WEST SUSSEX COUNTY COUNCIL CONSULTATION

TO:	Arun District Council FAO: Maria Tomalova
FROM:	WSCC - Highways Authority
DATE:	21 December 2020
LOCATION:	Royal Hotel The Esplanade Bognor Regis PO21 1SZ
SUBJECT:	BR/293/20/DOC Approval of details reserved by condition imposed under BR/257/19/PL relating to conditions 4-details of balcony railings, 5-covered & secure cycle storage spaces & 6-Travel Plan.
DATE OF SITE VISIT:	n/a
RECOMMENDATION:	Advice
S106 CONTRIBUTION TOTAL:	n/a

1. Lower Ground Floor Plan
scale 1:100

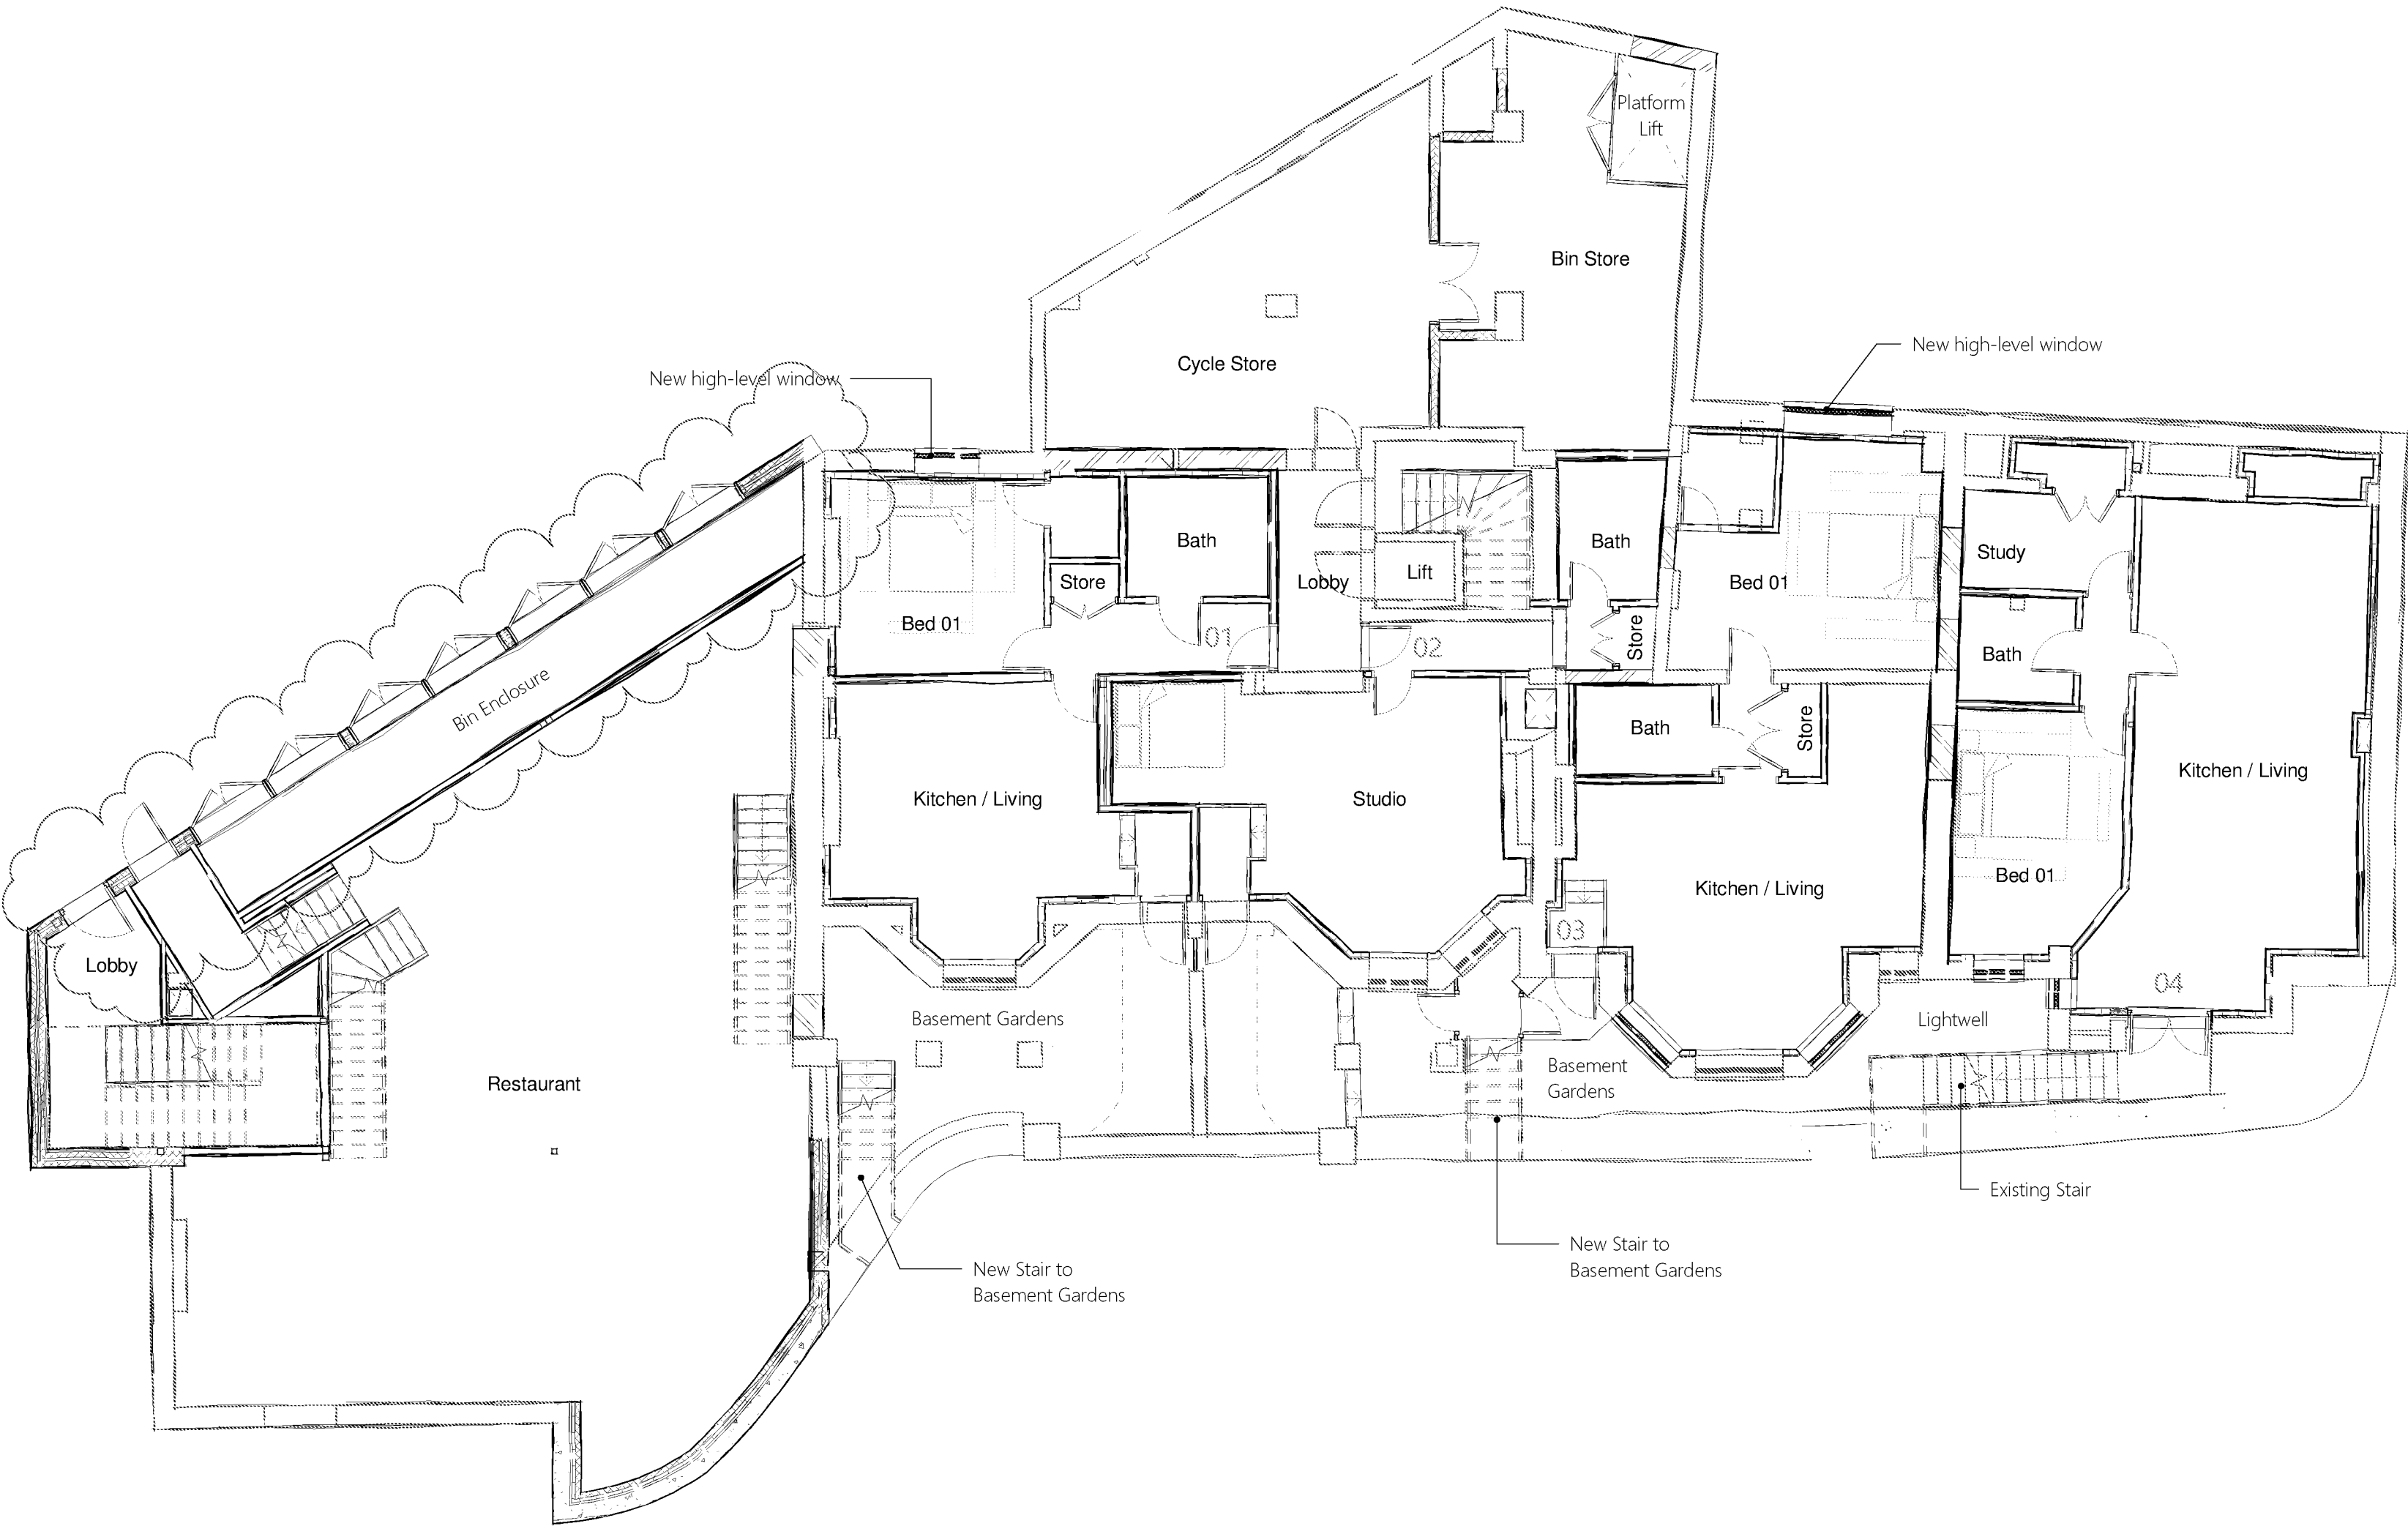
Condition 5 Cycle Parking-Secure and covered cycle parking has been shown on drawing 169/SK008. The LHA is satisfied that Condition 5 can be discharged.
